Hi Emma,

I refer to the points identified below in the email from AP&S and provide the following comments:

Road Reserve Width

TYPICAL ROAD 1 CROSS SECTION, CH0.00 - CH135.00

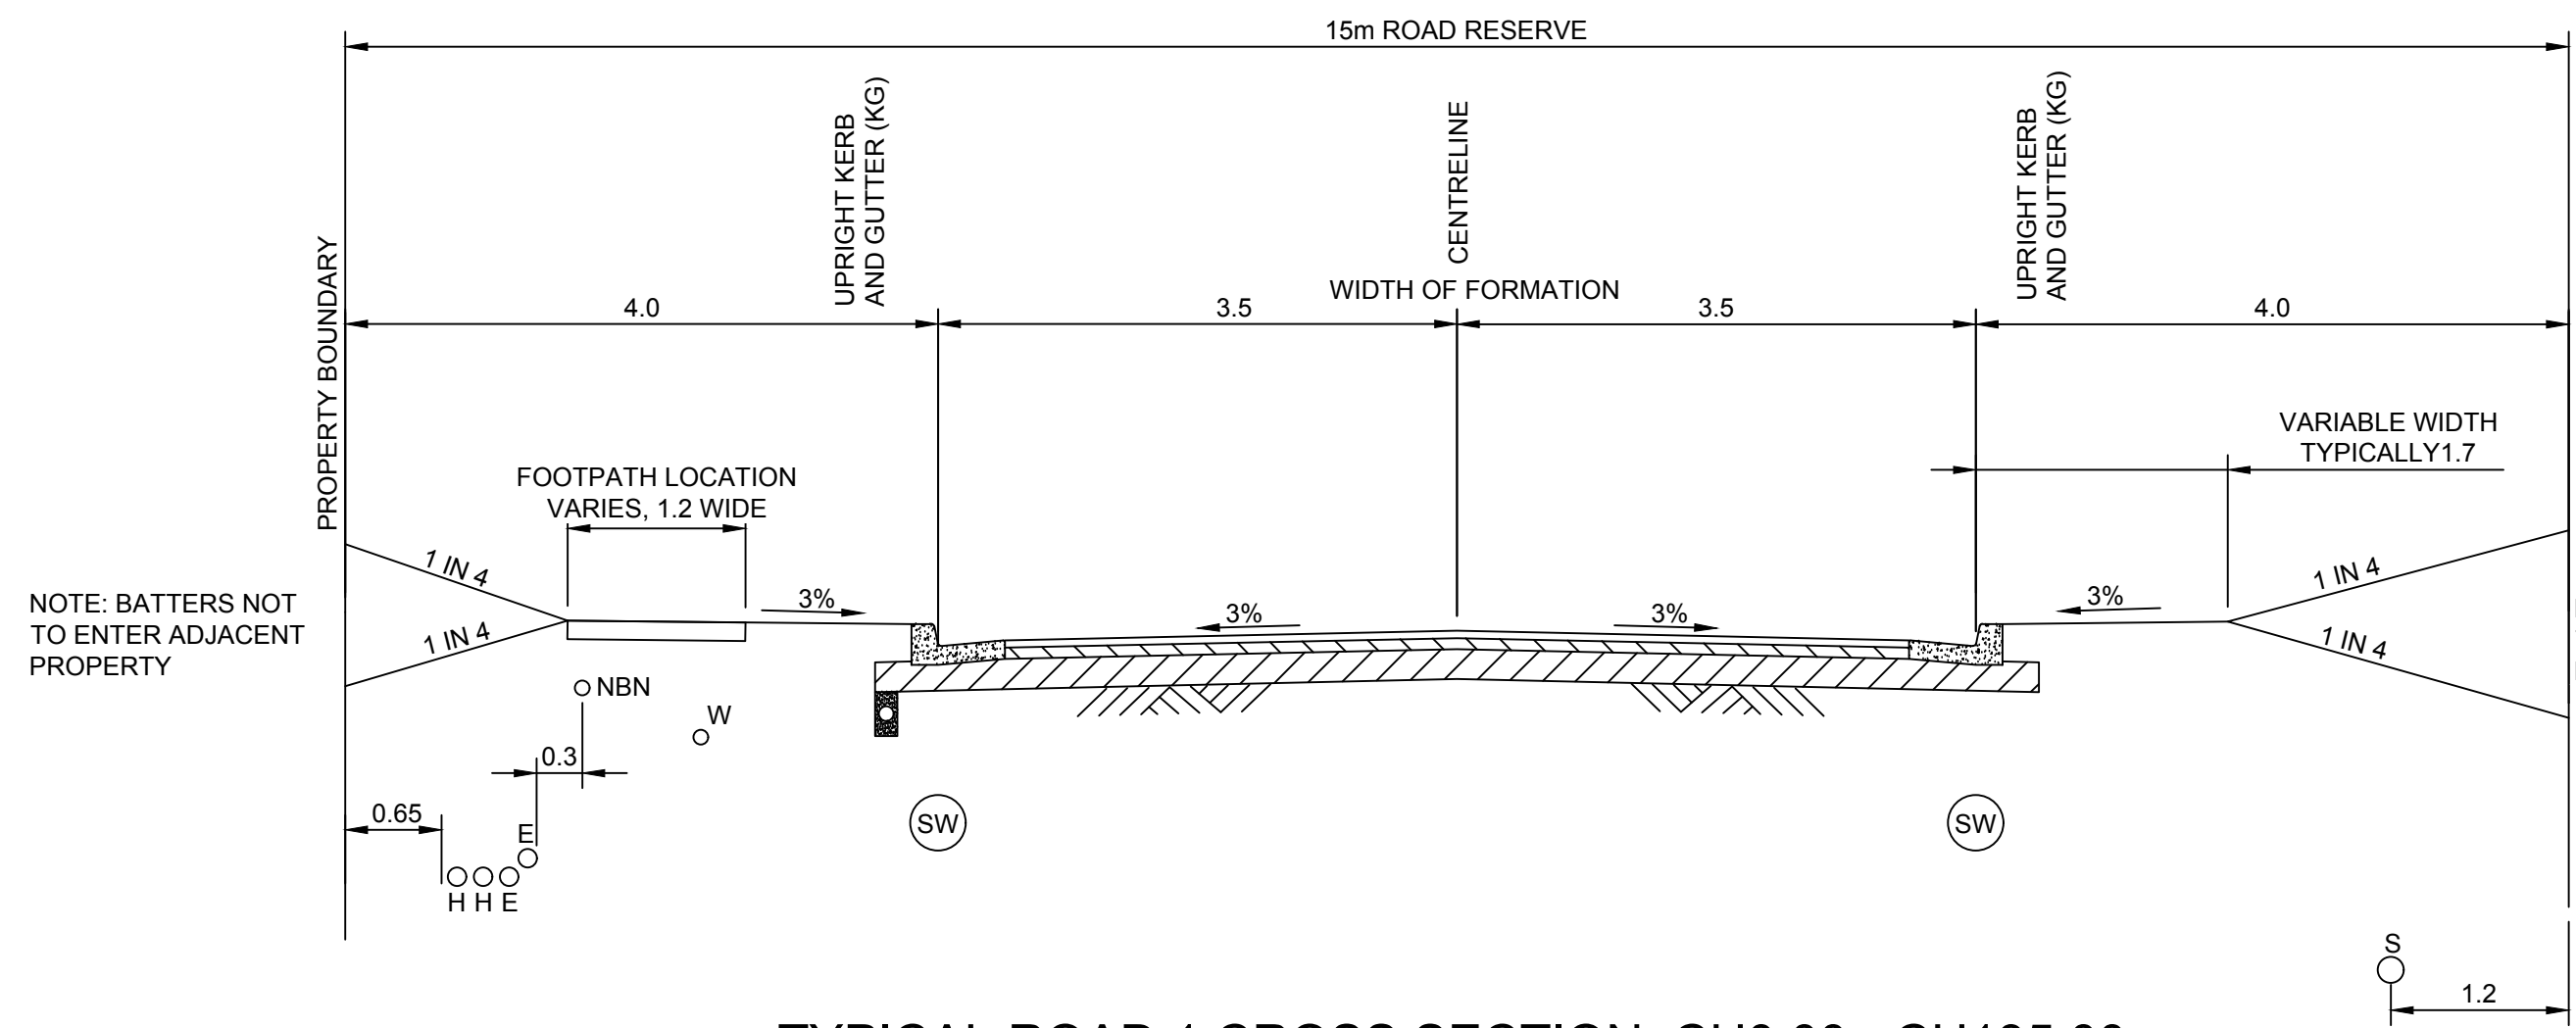
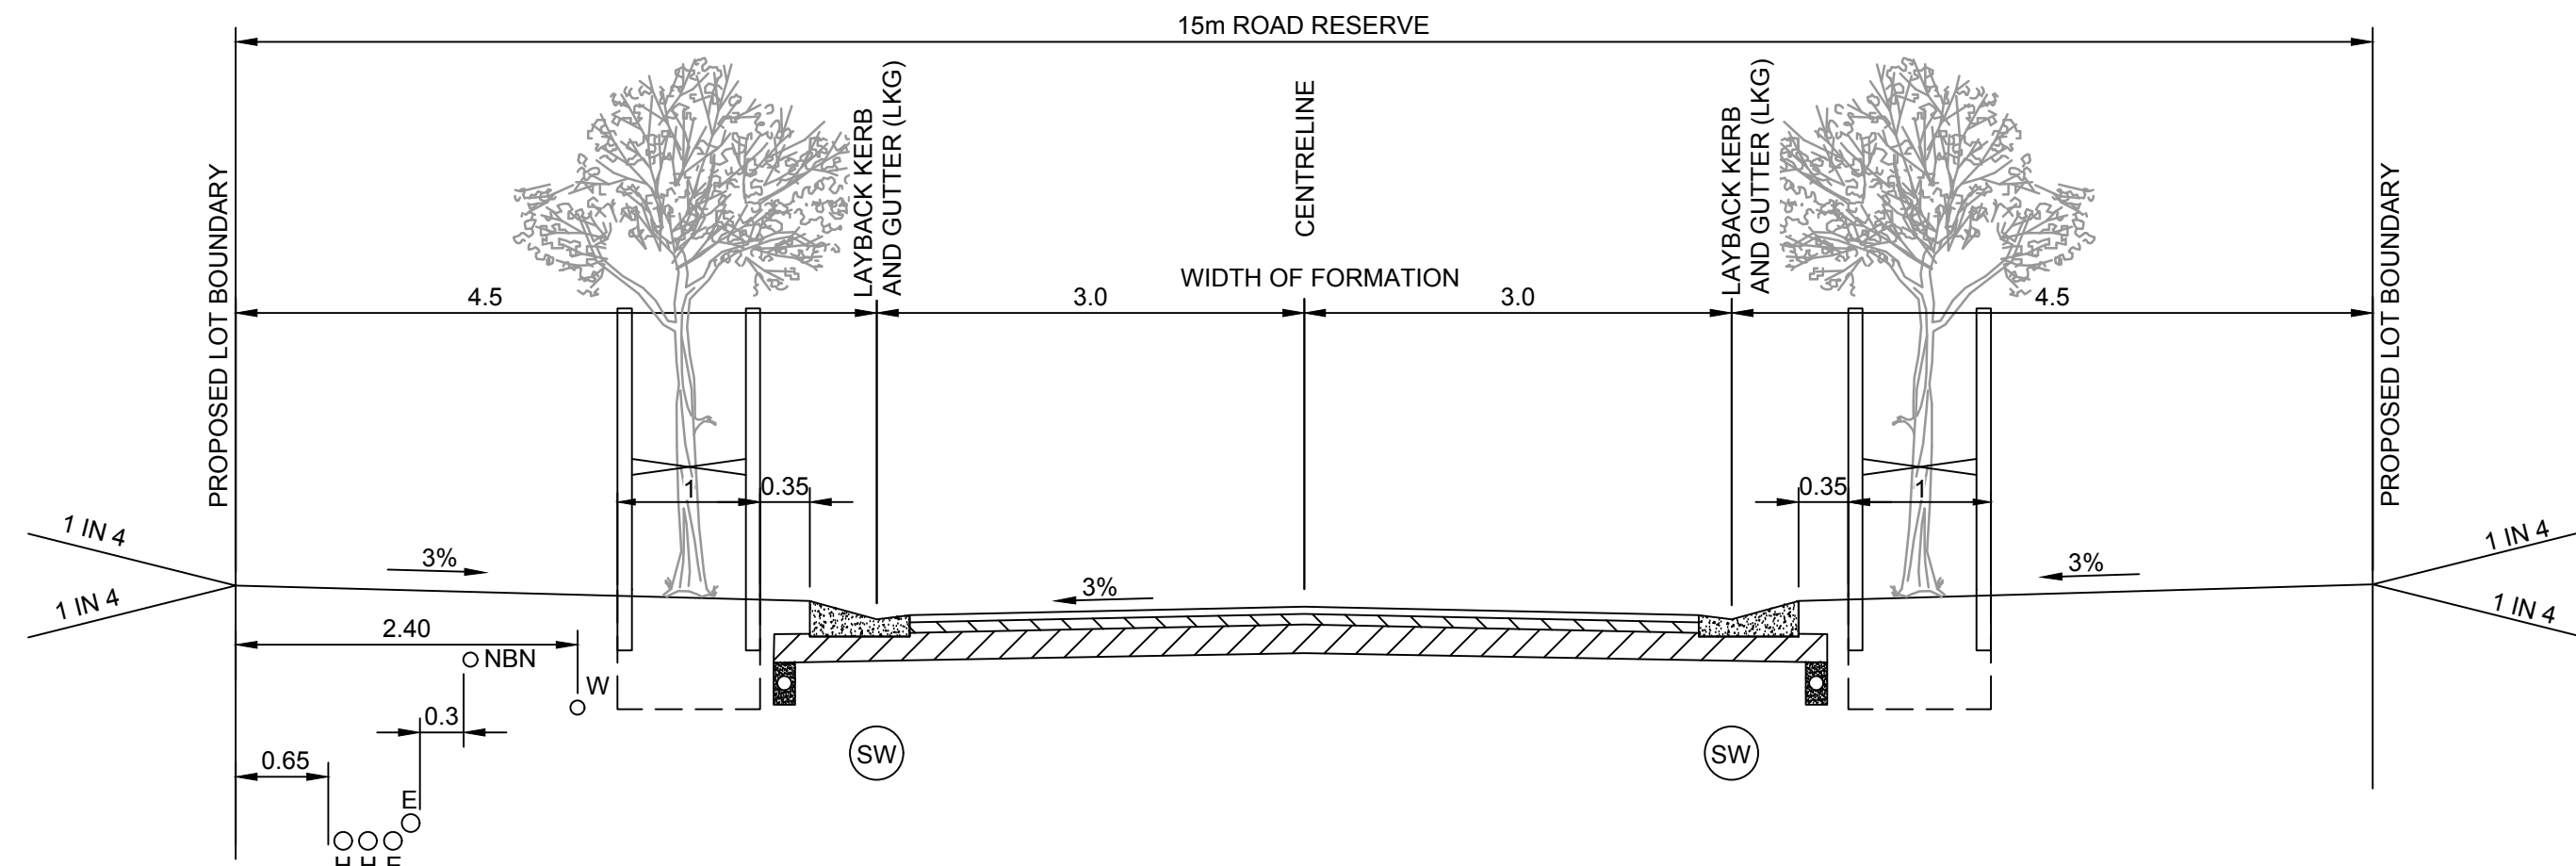
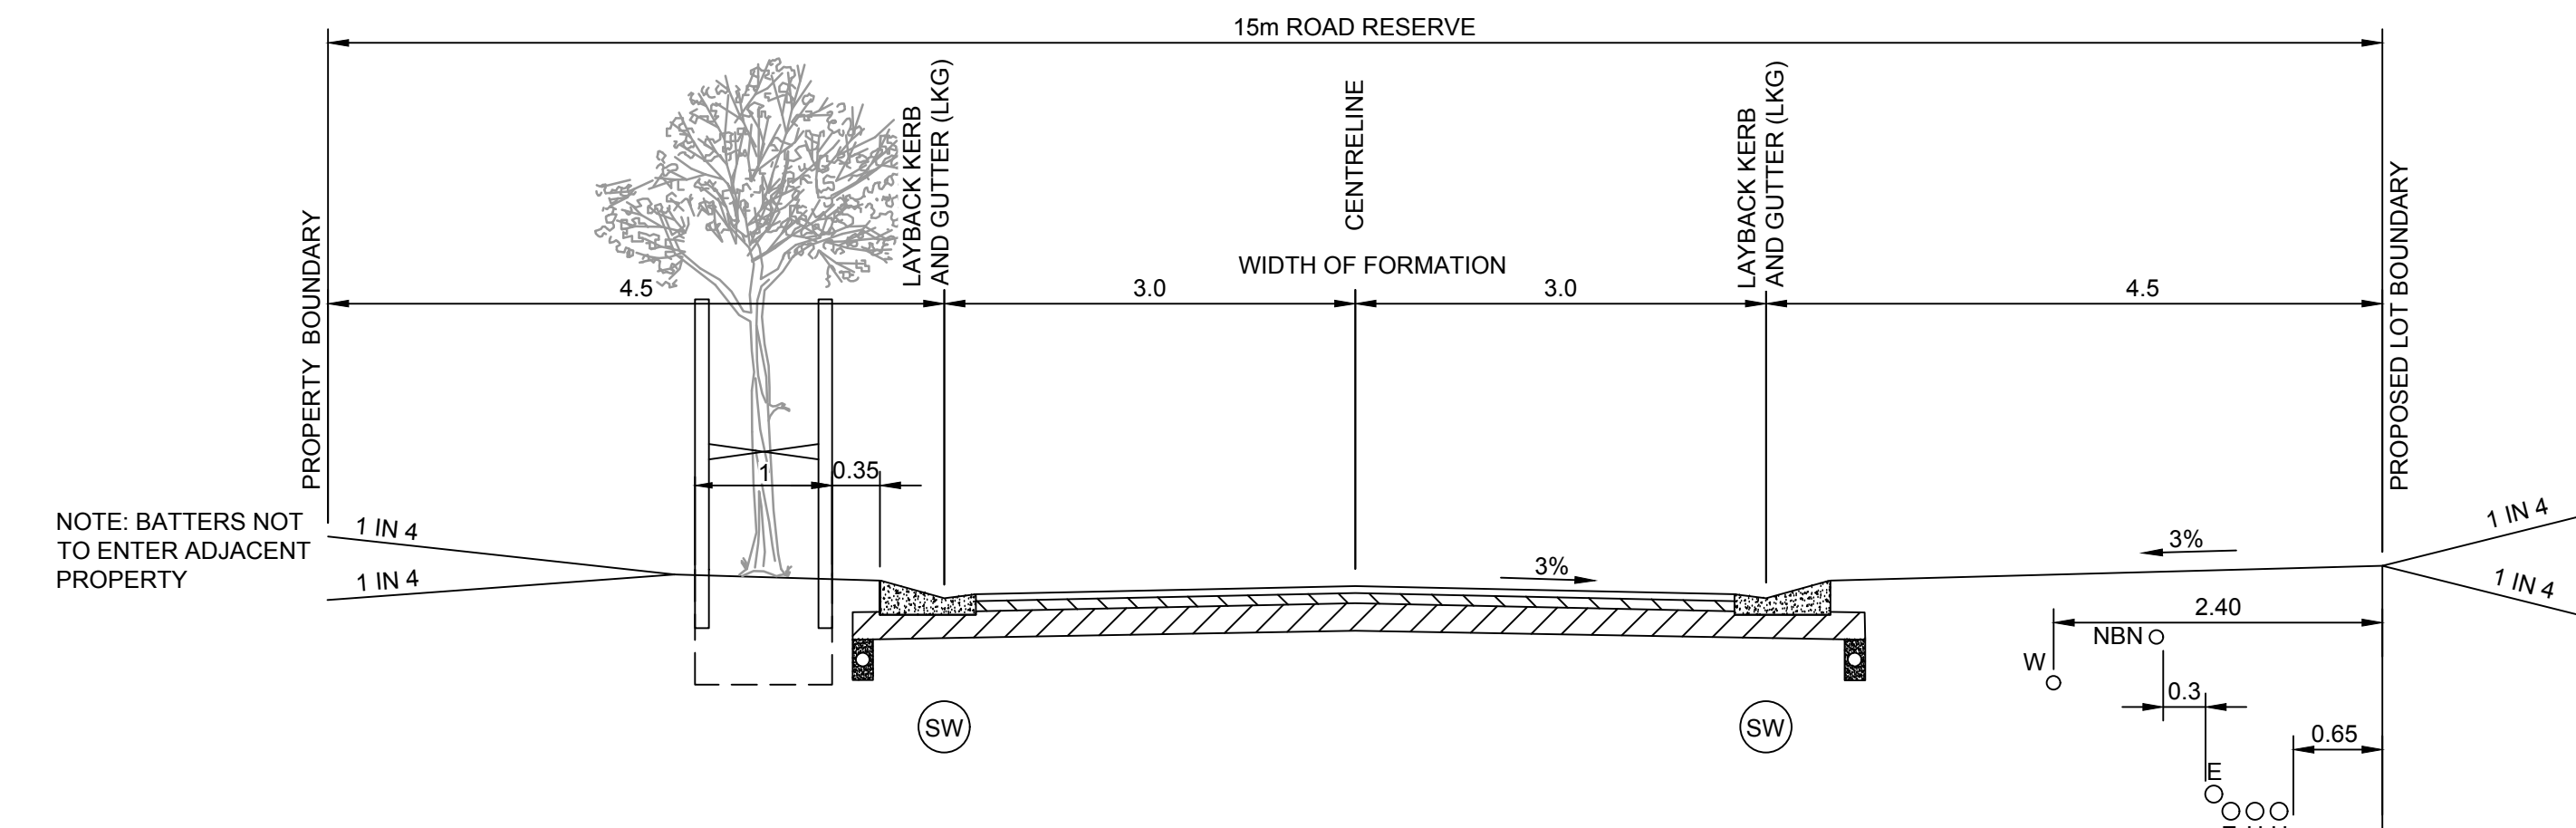
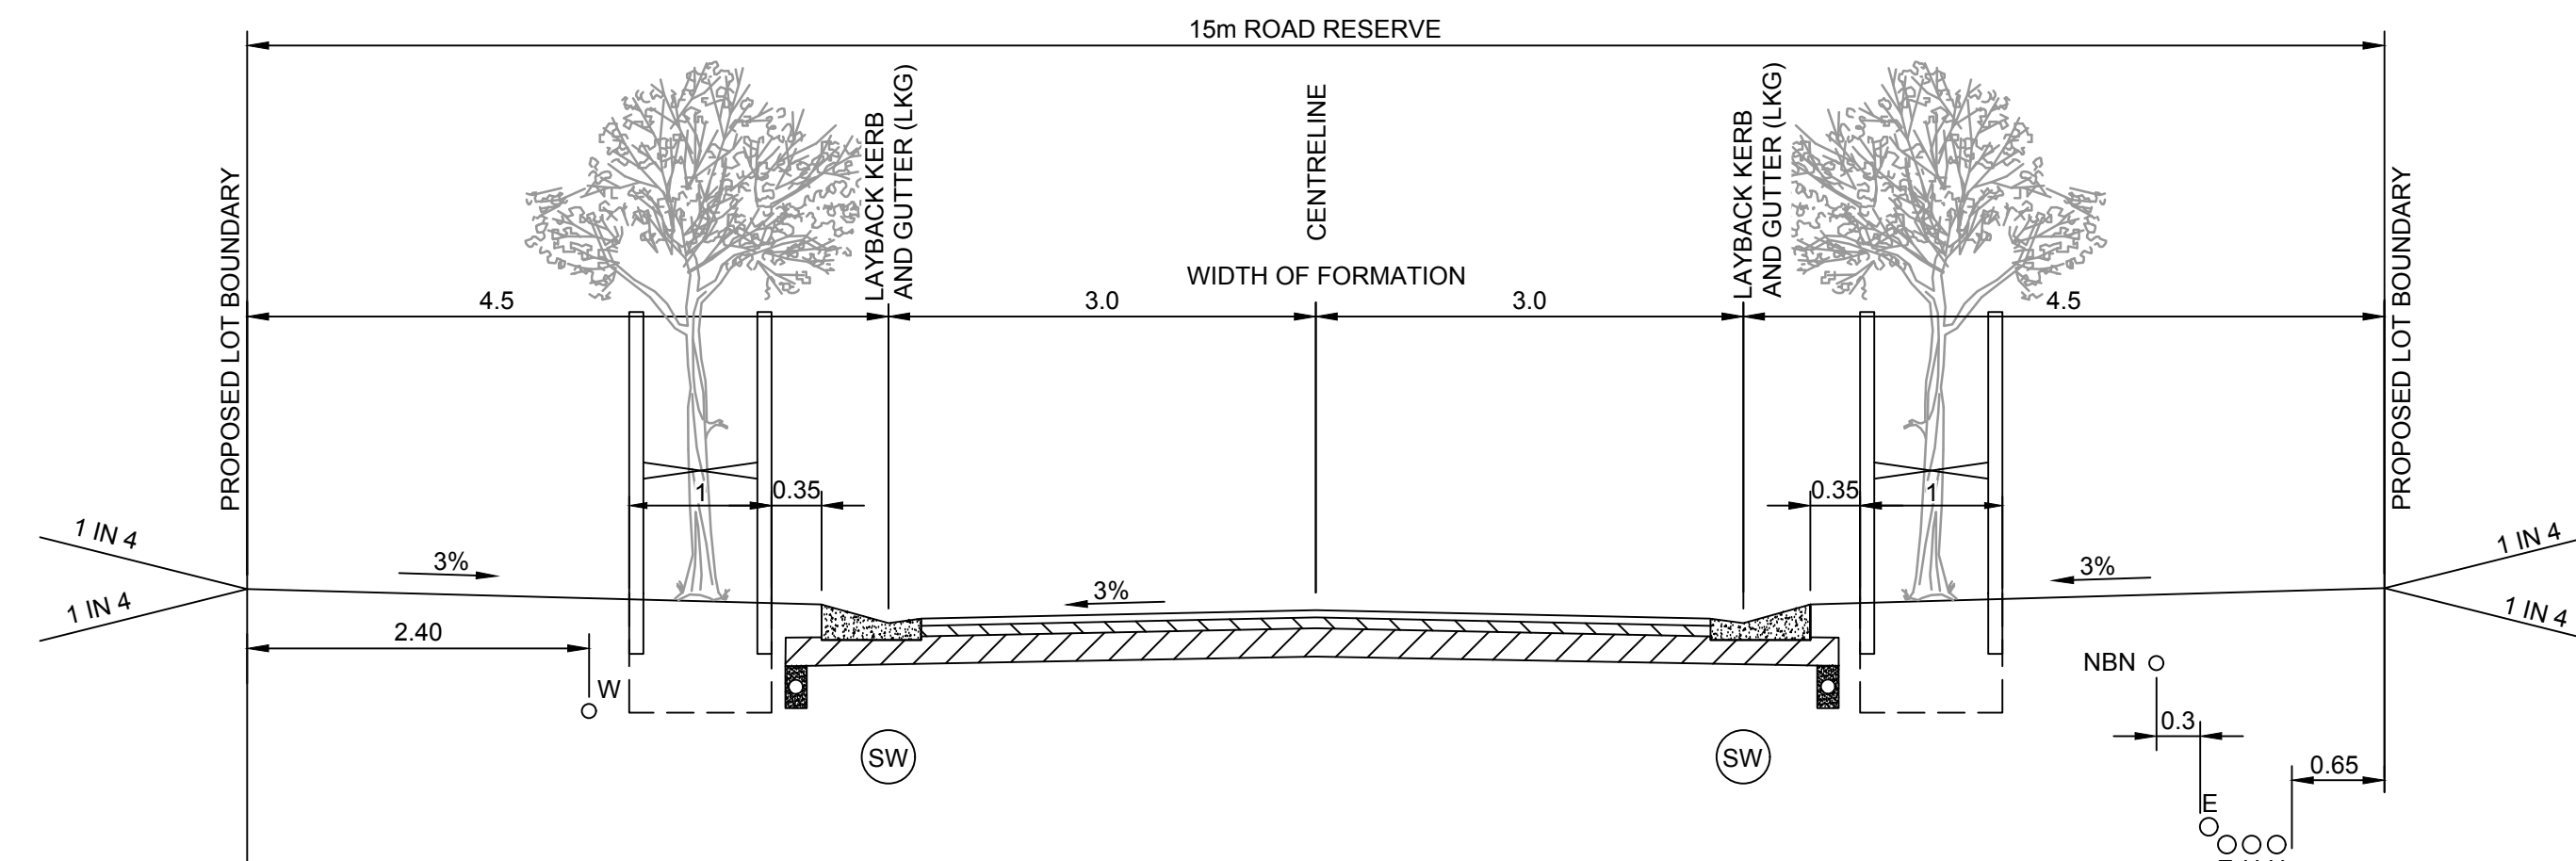
Council recognises the constraints of the layout and recommends the following road requirements.

- Road 1 (Entrance Road) CH0.00 to CH135.00,
 - 15m Road Reserve width as restricted by existing property boundary.
 - 7m wide carriageway (kerb invert to invert);
 - Upright Kerb – No property driveway required on this section of road
 - 2m width shared path on northern side

- Road 1 (Loop Road) CH135.00 - CH414.25 & CH135.00 - END
 - 16m Road Reserve width as per SDCP2014 Chapter G11.
 - 7m wide carriageway (kerb invert to invert);
 - Layback Kerb – for dwelling driveway;

- Road 1 (Section A) adjoining public reserve
 - **16m** Road Reserve width as per SDCP2014 Chapter G11.
 - **7m** wide carriageway (kerb invert to invert);
 - **Upright Kerb** – No property driveway required on this section of road;
 - **Open swale drain to** connect overland flow from drainage easement along the eastern side boundary of Lot 23 to drainage easement along eastern boundary of Lot 63,
 - **Multi-purpose:**
 1. for stormwater drainage management (to minimise overland run-off on road from northern drainage easement to Road 1 then discharge back to southern easement) and
 2. restrict future driveway access to existing dwellings on eastern side of subdivision

- Condition C9. 1) c. The entrance road shall have a 15m road reserve width with a 7m wide carriageway (kerb invert to invert) with upright kerb. The loop road shall have a 16m road reserve width with a 7m wide carriageway (kerb invert to invert) with layback kerb. Upright kerb is to be used on the section of road adjoining the public reserve. *(the remainder of C9.1c) to continue as per draft)*
- New condition C12 d) An open swale drain is to be constructed within the 2m wide public reserve to connect the overland flow from the drainage easement along the eastern side boundary of Lot 23 to the drainage easement along the eastern boundary of Lot 63
